SITE DEVELOPMENT PLAN
7315 COLE V
EL PASO COUNTY, COLORADO

DETENTION POND DETAILS
PROJECT NO. 21813-00CSCV
DRAWING NO.

SITE DEVELOPMENT PLAN FOR:
7315 COLE VIEW
EL PASO COUNTY, COLORADO

CONCRETE FOREBAY DETAILS

**PERMANENT  
BMP  
COVER SHEET**

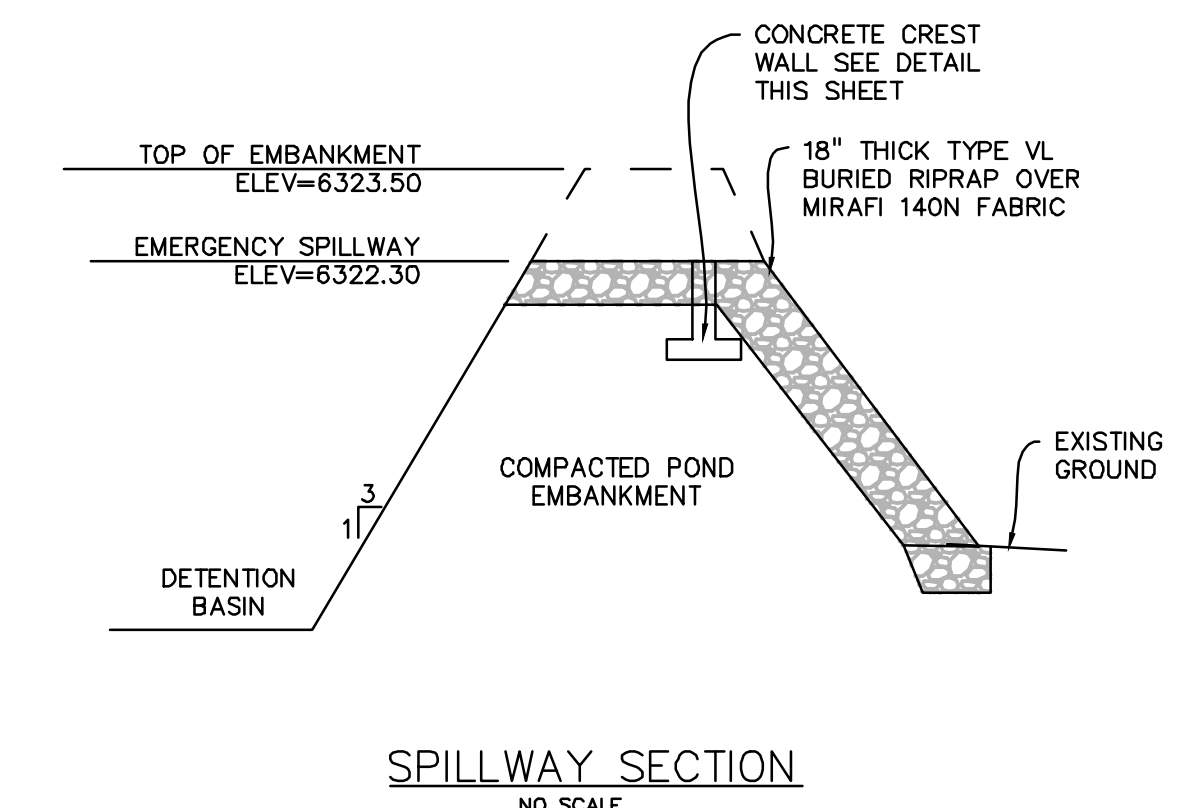
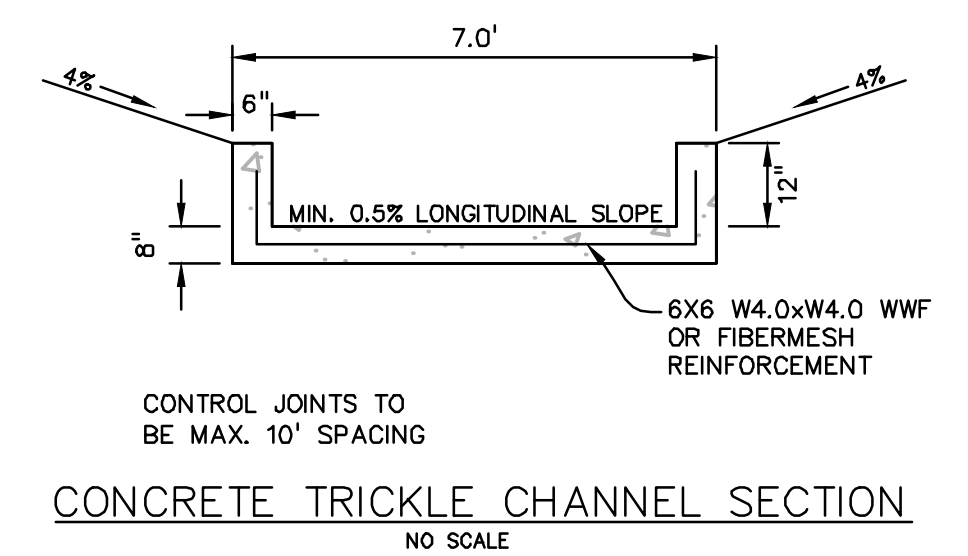
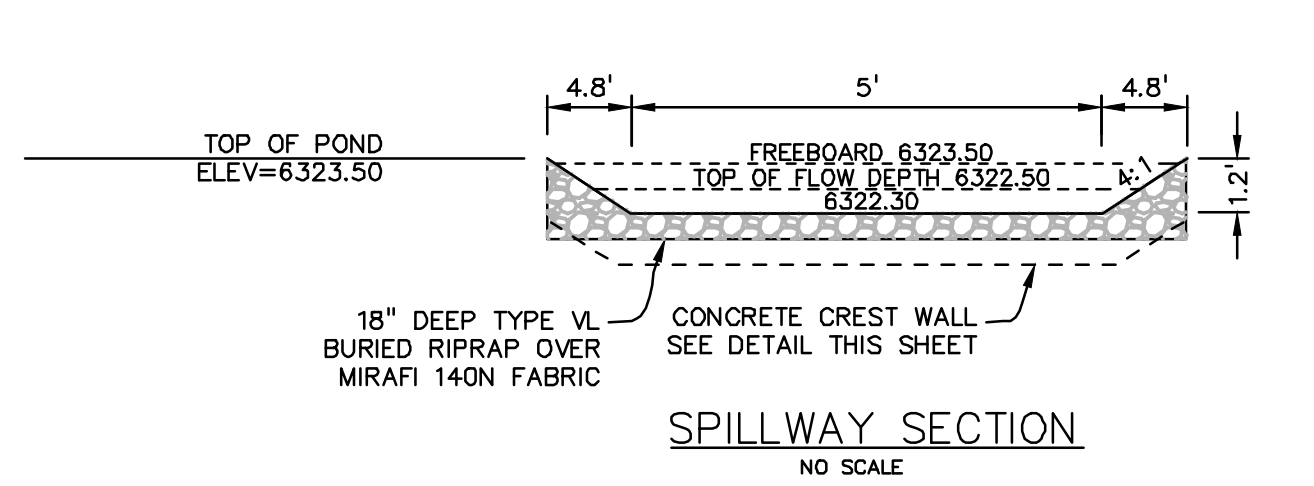
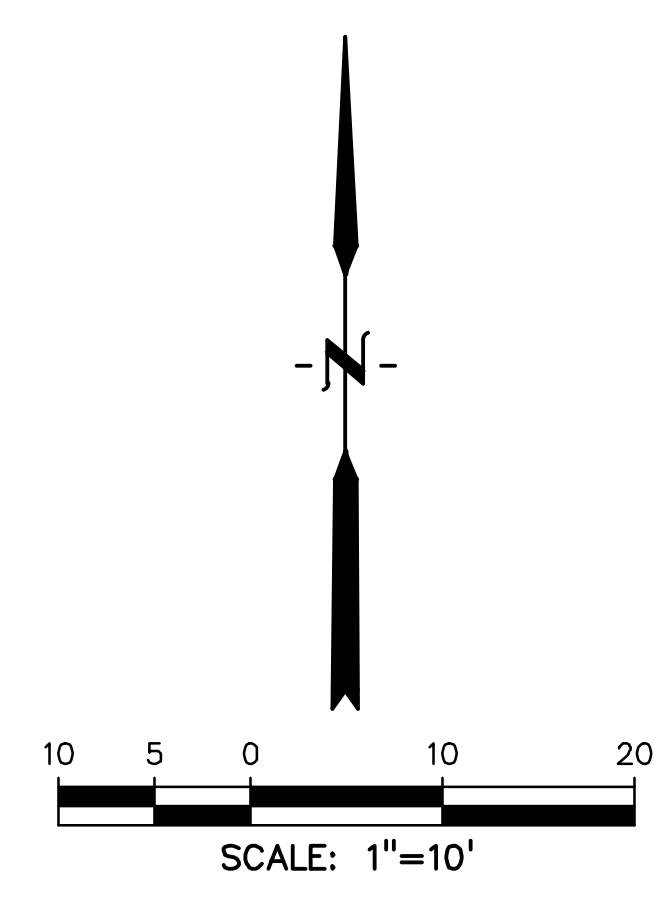
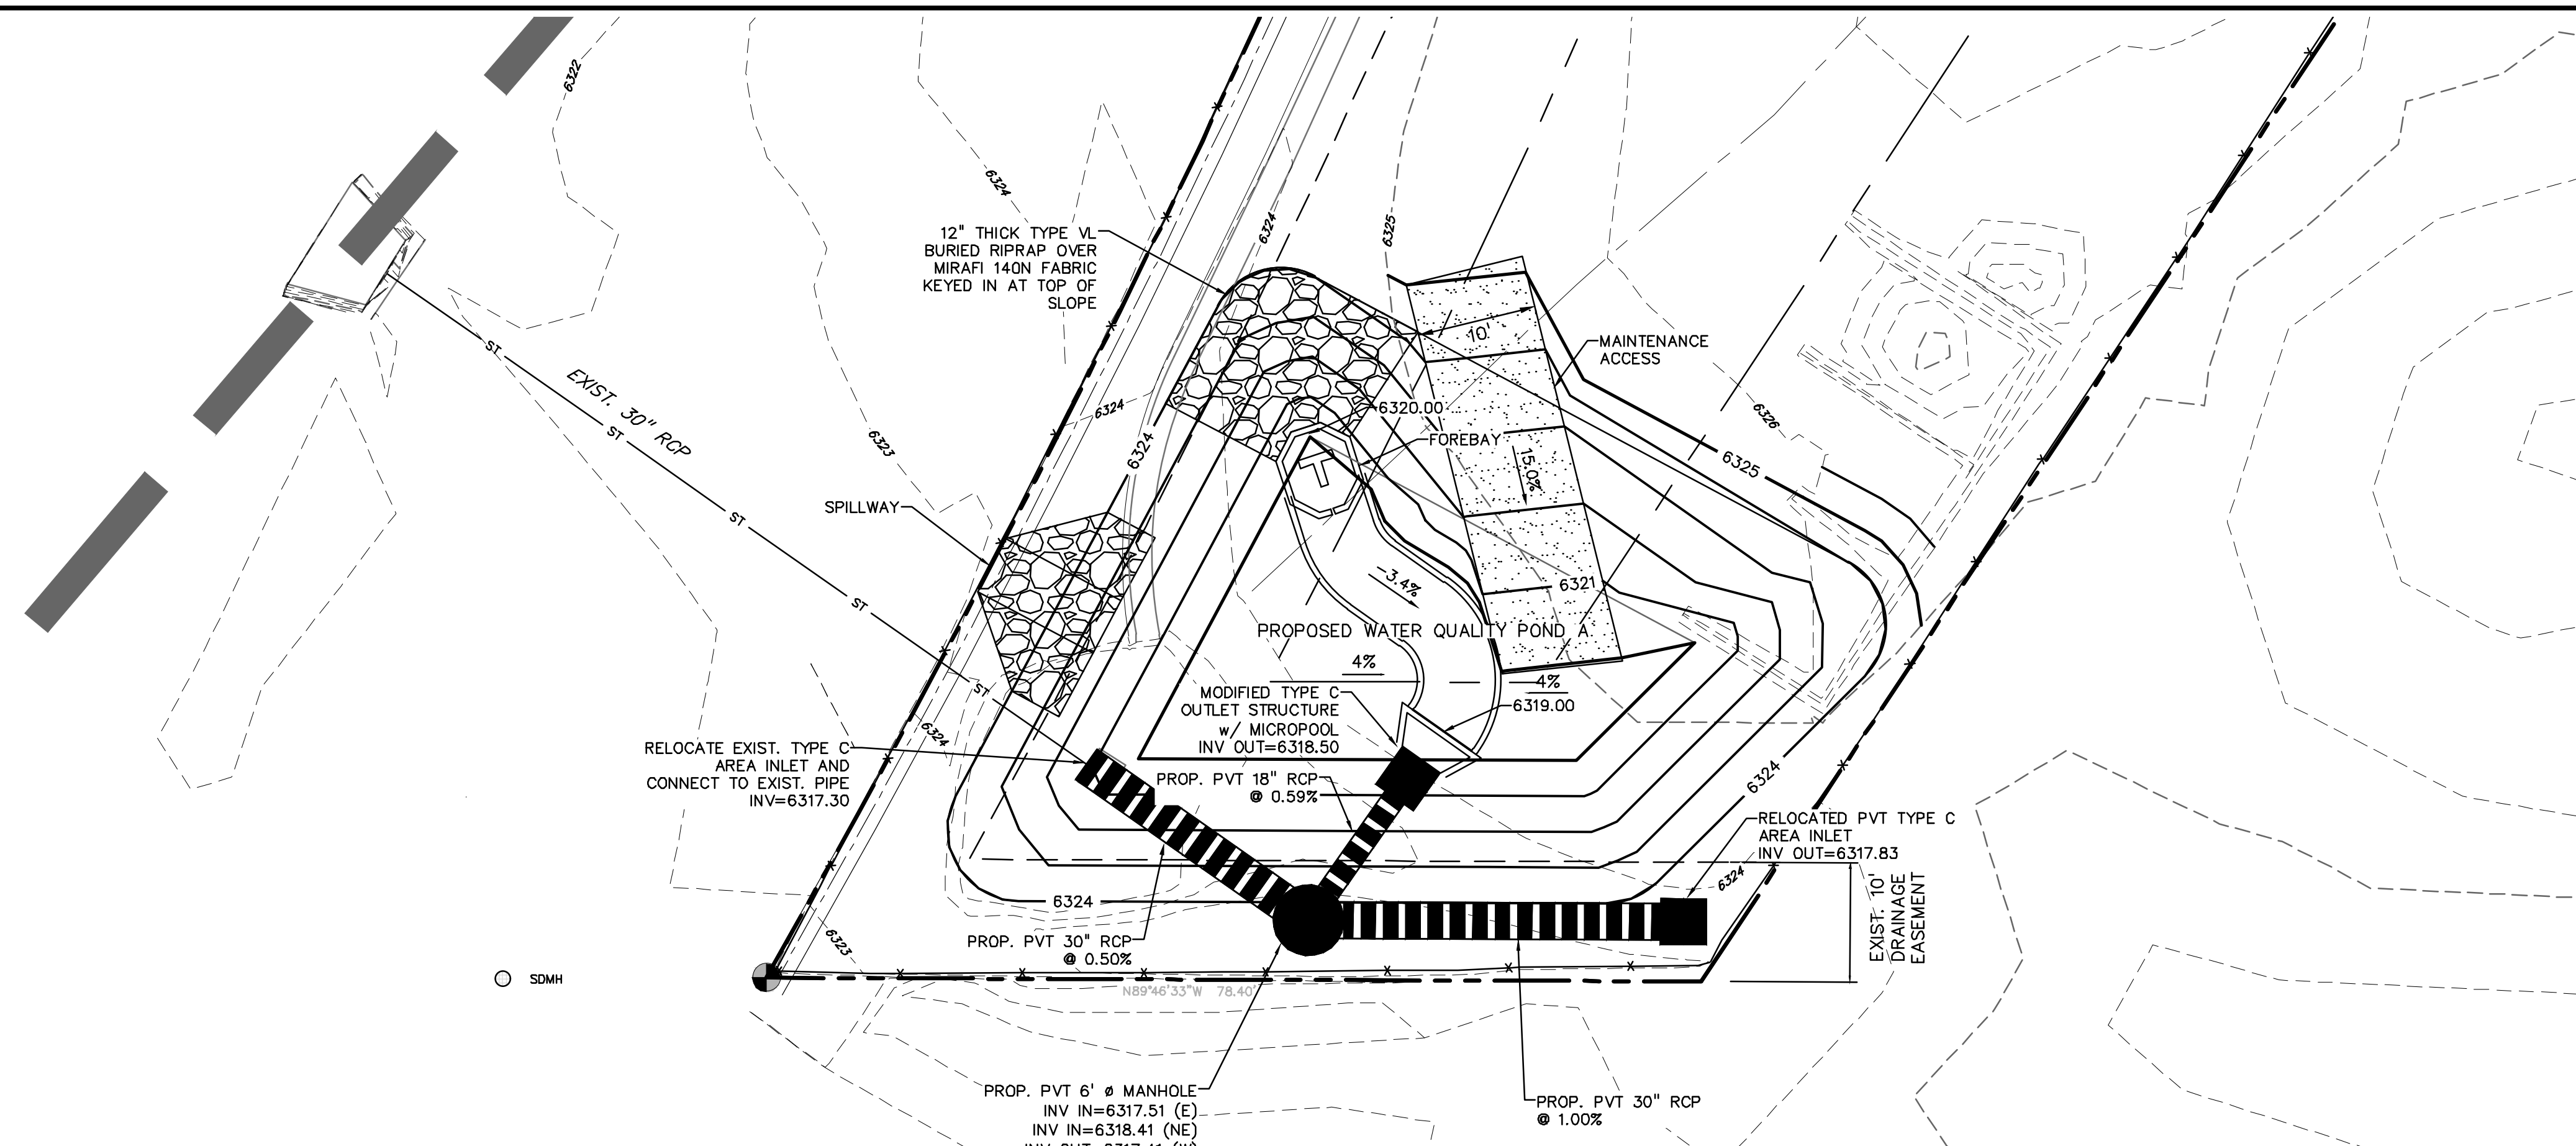
These drawings need to have a cover sheet with signature blocks. Or these details can be put in the GEC Plans.

CDs need to be stamped.

Update to provide a cover sheet with the following signature blocks if intending to keep separate from GEC Plan:
Construction Drawings

update to add construction notes to cover page:

DETENTION POND DETAILS

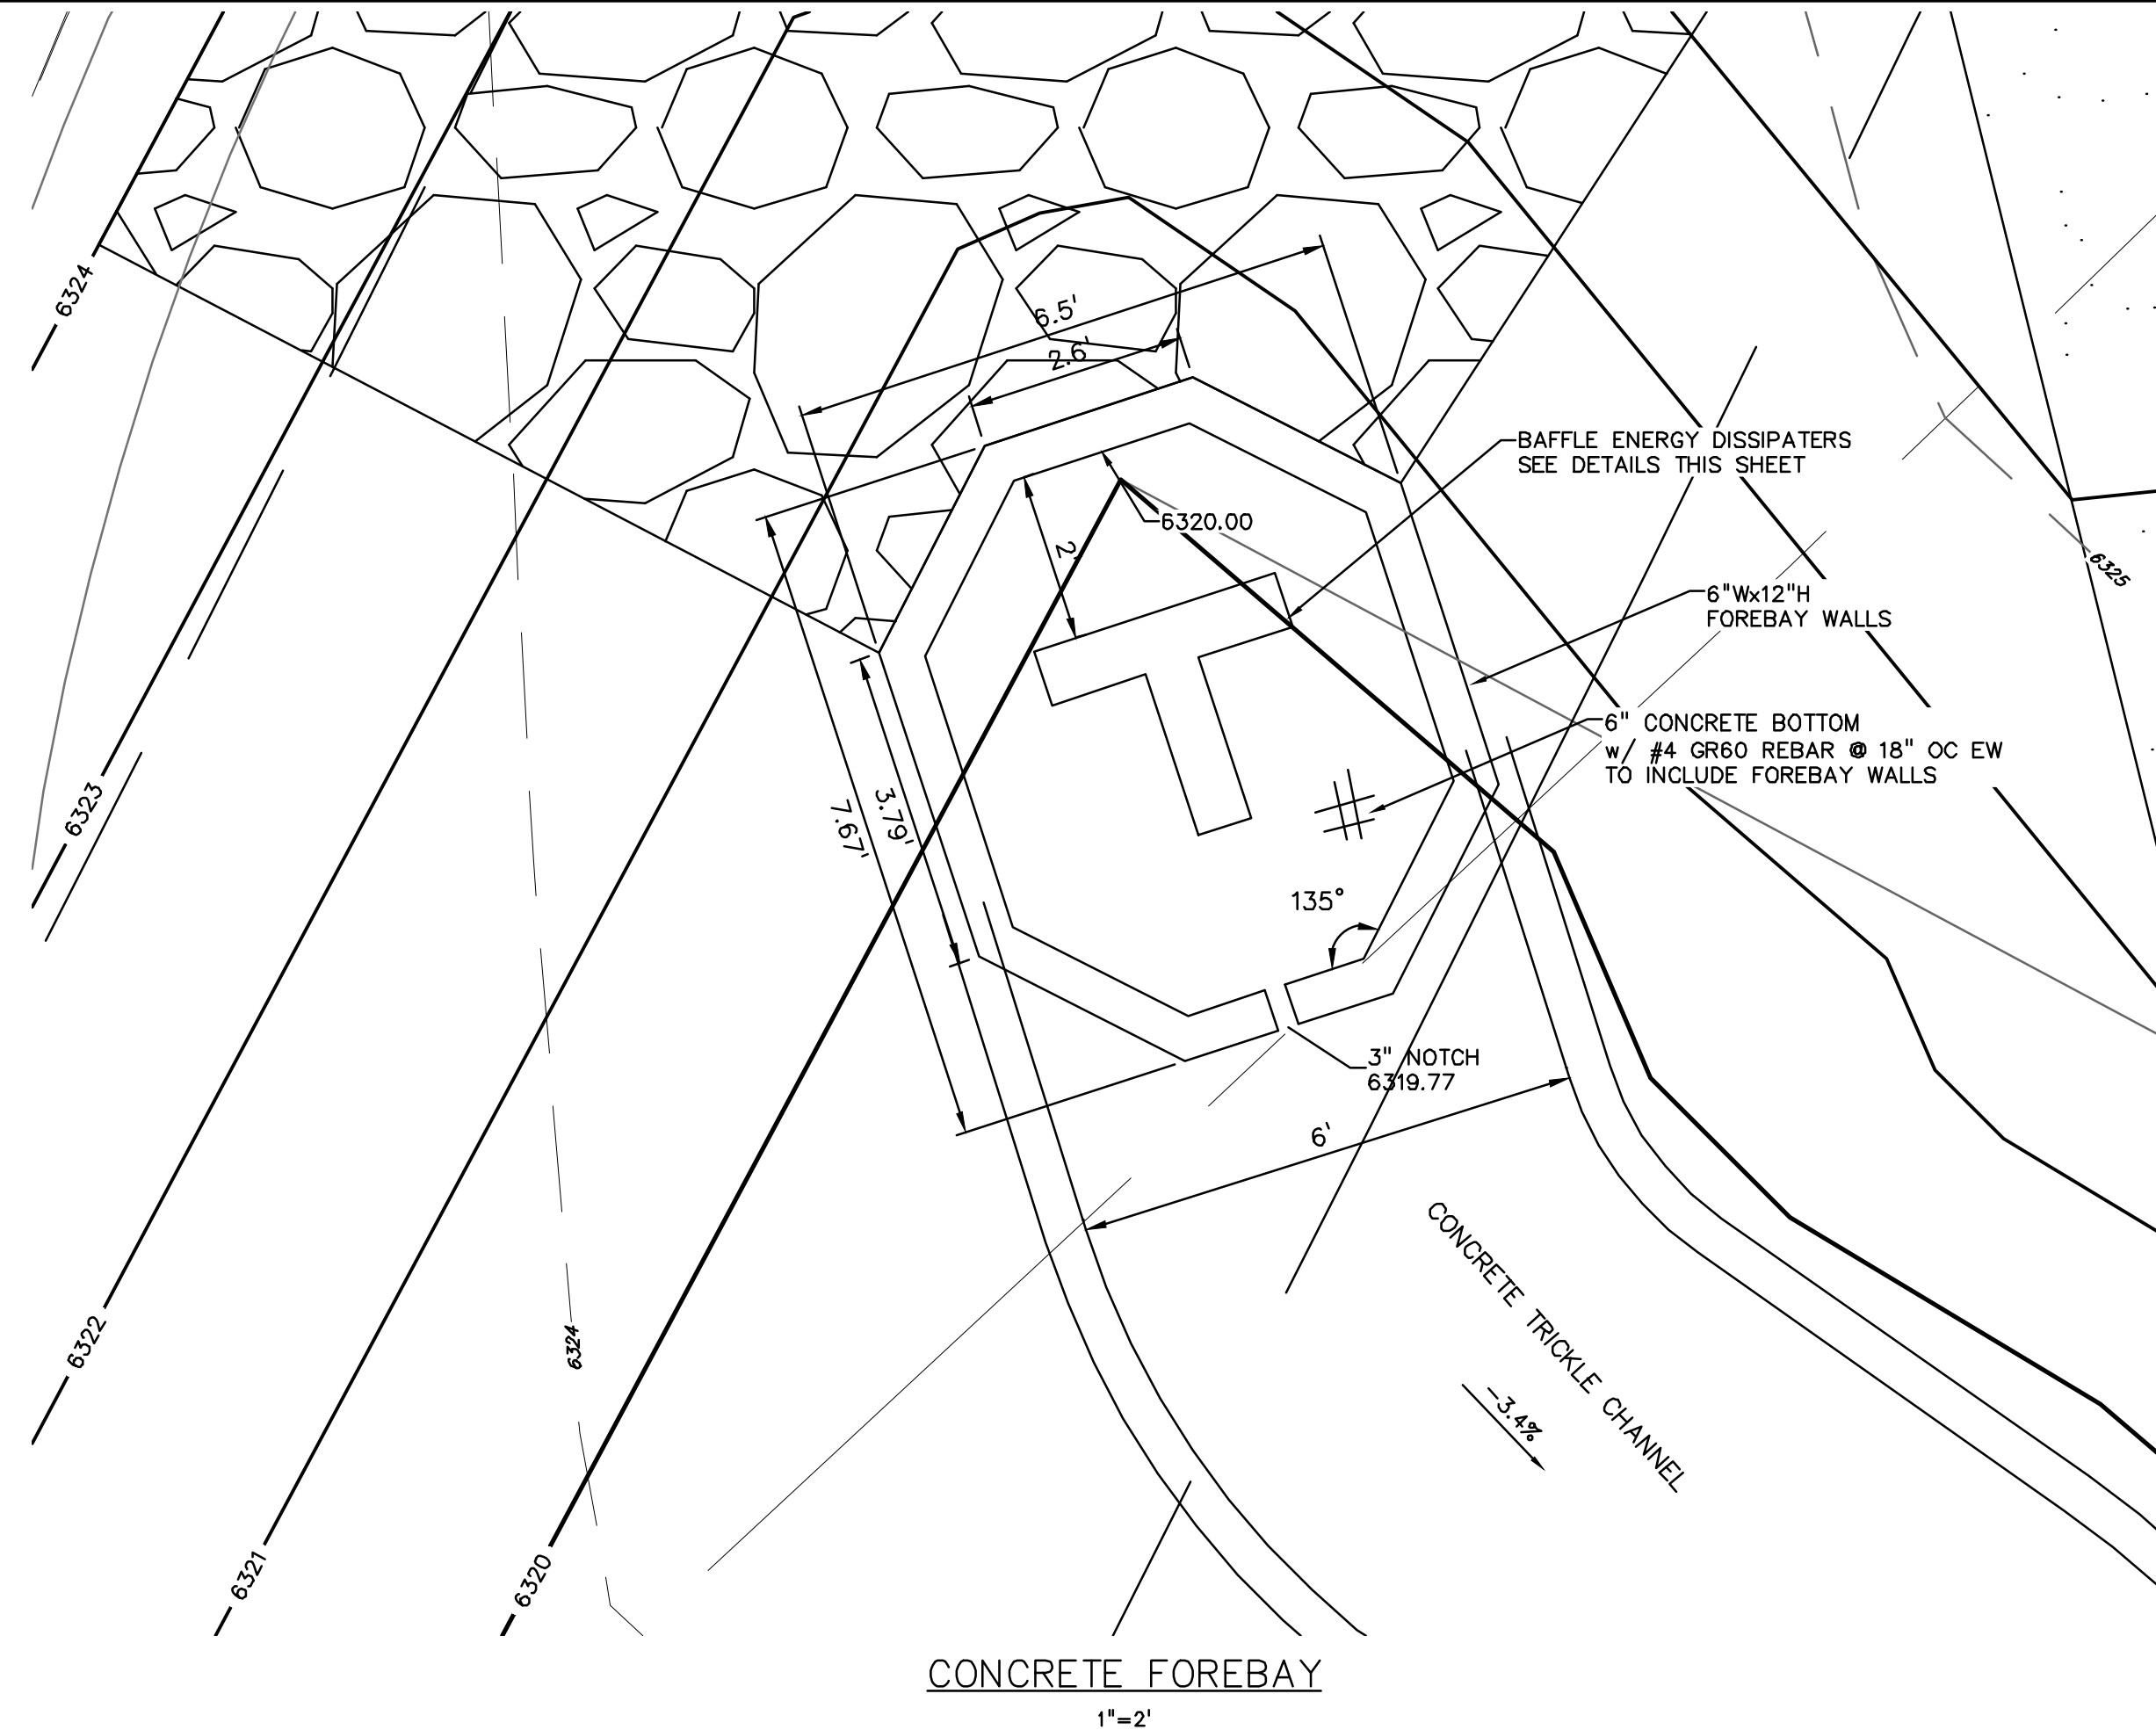
how is this depth only 1.2' if the riprap is 18" and it is buried this depth would need to be greater than 1.5'.

Provide maintenance access road and detail/cross section, including stone sizing and gradation. Show cross slope at 2%. Stabilized access ramp shall be a minimum of 15ft wide and no greater than 12% slope, in accordance with DCMv1, Chap 11.2.2. It may be acceptable to design the access road with a narrower width, greater slope, and without extending it to forebay(s) and outlet structure if the anticipated maintenance vehicles and equipment can still safely access the pond and reach structures. Properly document this in the Pond O&M manual.
